To: Senior Strategic Planner
Acting Strategic Planning Coordinator

From: Transport Planner

Date: 25 October 2021

Subject: Edmondson Park Primary School

Figure 21 - School Access Plan

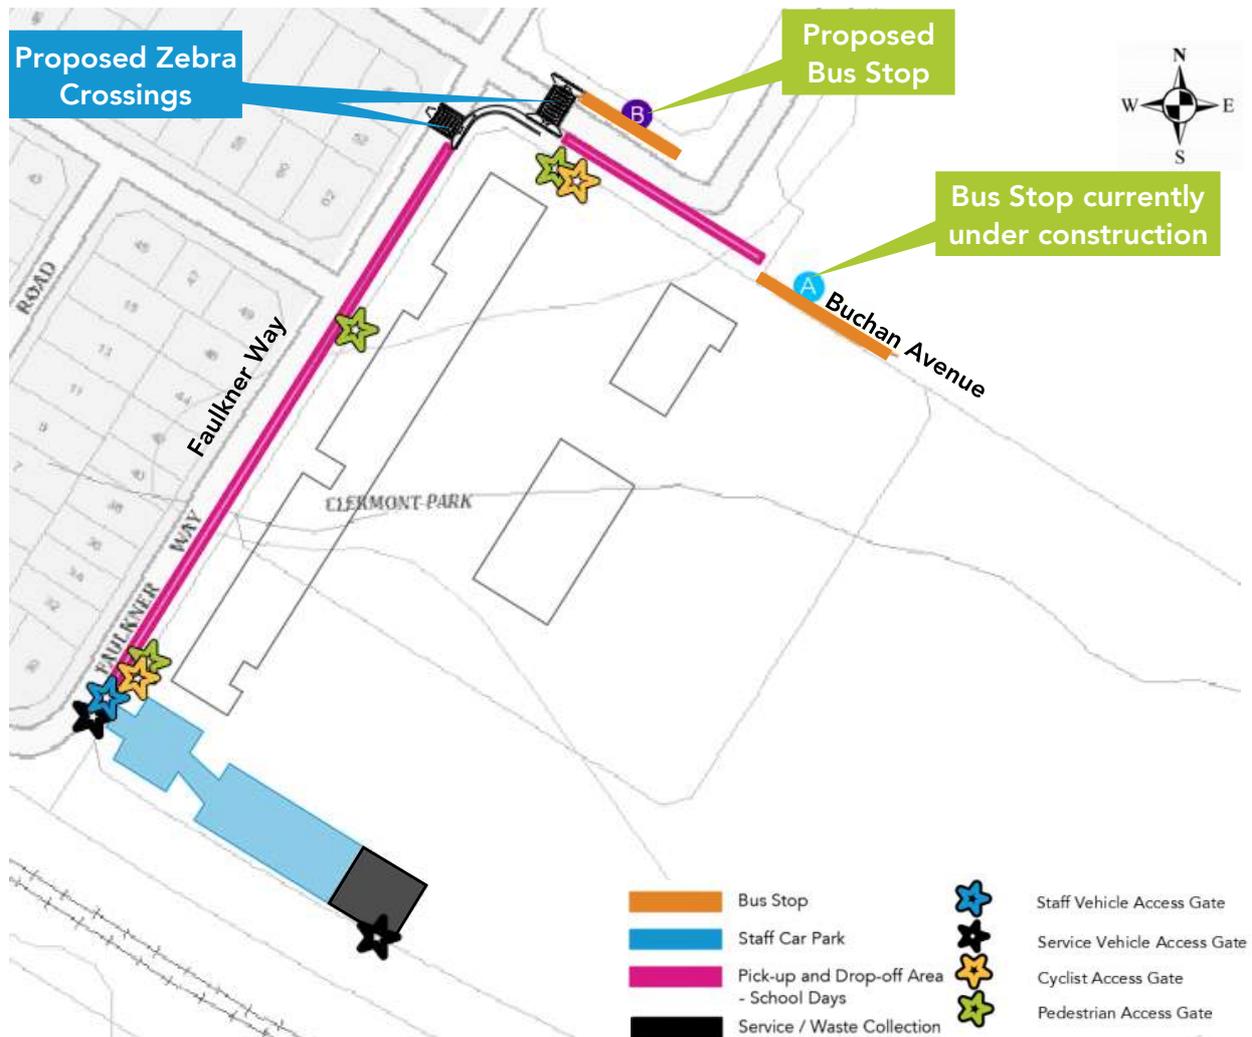
- To reduce traffic conflict and improve road safety at the intersection, the intersection is to include interim and long-term treatments:
 - The interim treatment is dedicated right turn lane and shared left/through lane on Faulkner Way southern approach and split islands in Buchan Avenue.

- This includes the need for a U-turn bay at the end of Faulkner Way to facilitate the exit U-turn movements.
- Marked pedestrian crossings across sections of Buchan Avenue and Faulkner Way are supported. The locations and designs are to be submitted to the Liverpool Traffic Committee for assessment, prior to installations.

Figure 44 - Journey to Work from Edmondson Park Area

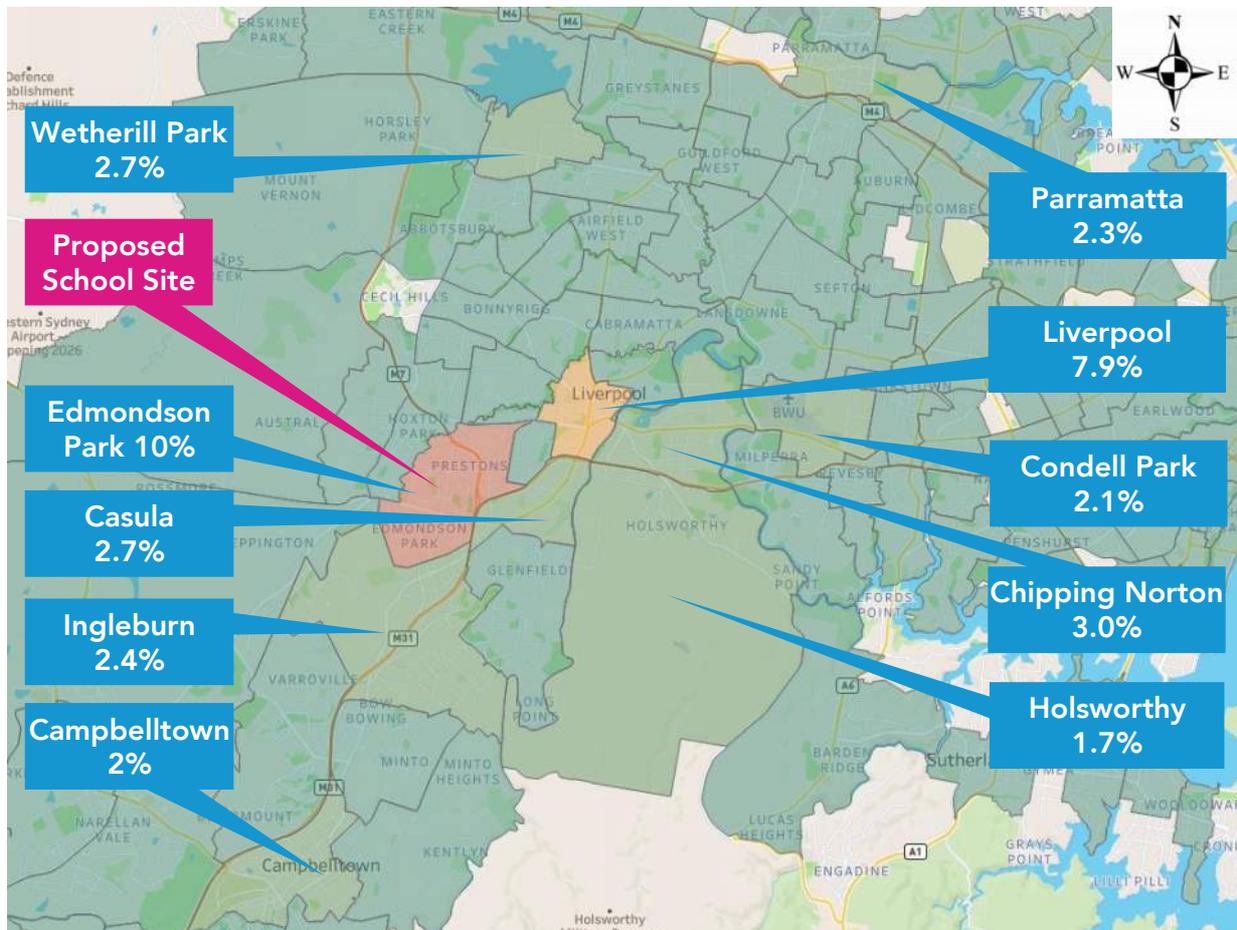
- The forecast traffic assignments (20% heading north and 80% heading south) as shown in Figure 7 will require construction of the proposed new north-south road connecting to Bunchan Avenue.

- The link road is to be constructed prior to the issue of Occupation Certificate.
- The school to be made advised that that an official Crossing Supervisor needs to be applied for directly to TfNSW. An application for a new school crossing supervisor should be lodged with TfNSW prior to the opening of the new school.
